CITY OF PORTLAND BUILDING PERMIT

PERMIT ID: 2012-46525

has permission to **Enclosing existing deck - 12' x 14'**

RE: 21 Quiet Lane – 388A-A-053 – R-2 Zone - permit application #2012-07-4580

Misc Plot Plan

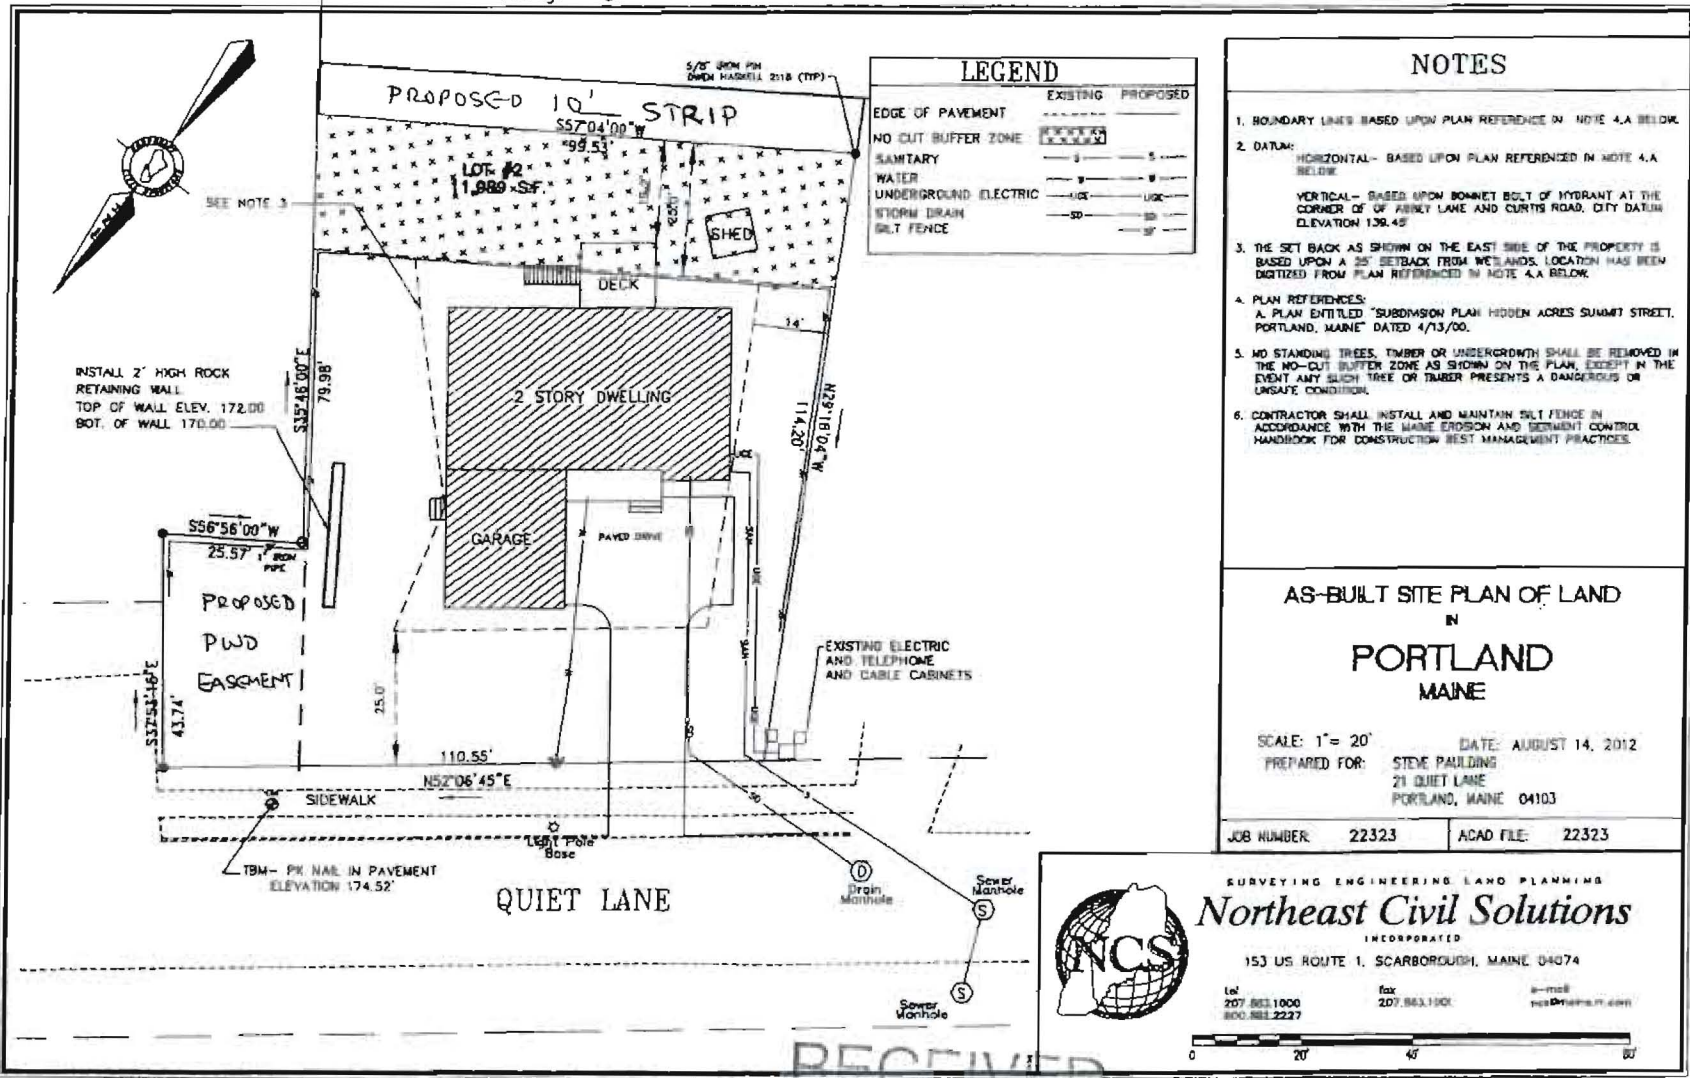
Based upon a review of the file, it appears that the property owner will need to seek an amendment to the subdivision plat from the Planning Board for the deck that extends into the no cut area; however it appears that the deck does not impact a wetland. The existing survey for 21 Quiet Lane shows a shed located in the no-cut area, which should be relocated out of the no-cut buffer.

First of all, I find no permit on file for the original deck. Such an addition does require a building permit. Apparently the deck was erected without the required review and permit. Based upon the original approved survey site plan, I believe the added deck is located in the required rear setback and within the no cut buffer zone as depicted on the approved site plan (enclosed). The R-2 zone in which this property is located requires a minimum 25 foot rear setback under section 14-80(d)(2).

1) Deck was built in "no cut" zone. Consent Agreement was signed between the property owner and the City on March 5, 2013 allowing the deck to remain and be maintained.or replaced within the existing footprint.

- (a) Paulding shall acquire a ten-foot (10') wide strip at the rear of the Property from PWD on or before April 1, 2013, which the parties have agreed is sufficient to cure the setback violation; and

- (b) Paulding has agreed to place the same "no-cut" restriction on the property acquired from PWD as the area where her shed is currently located (as shown in attached exhibit B). The City hereby agrees to allow Paulding's aforementioned shed to remain in its present location (as shown in attached exhibit B).
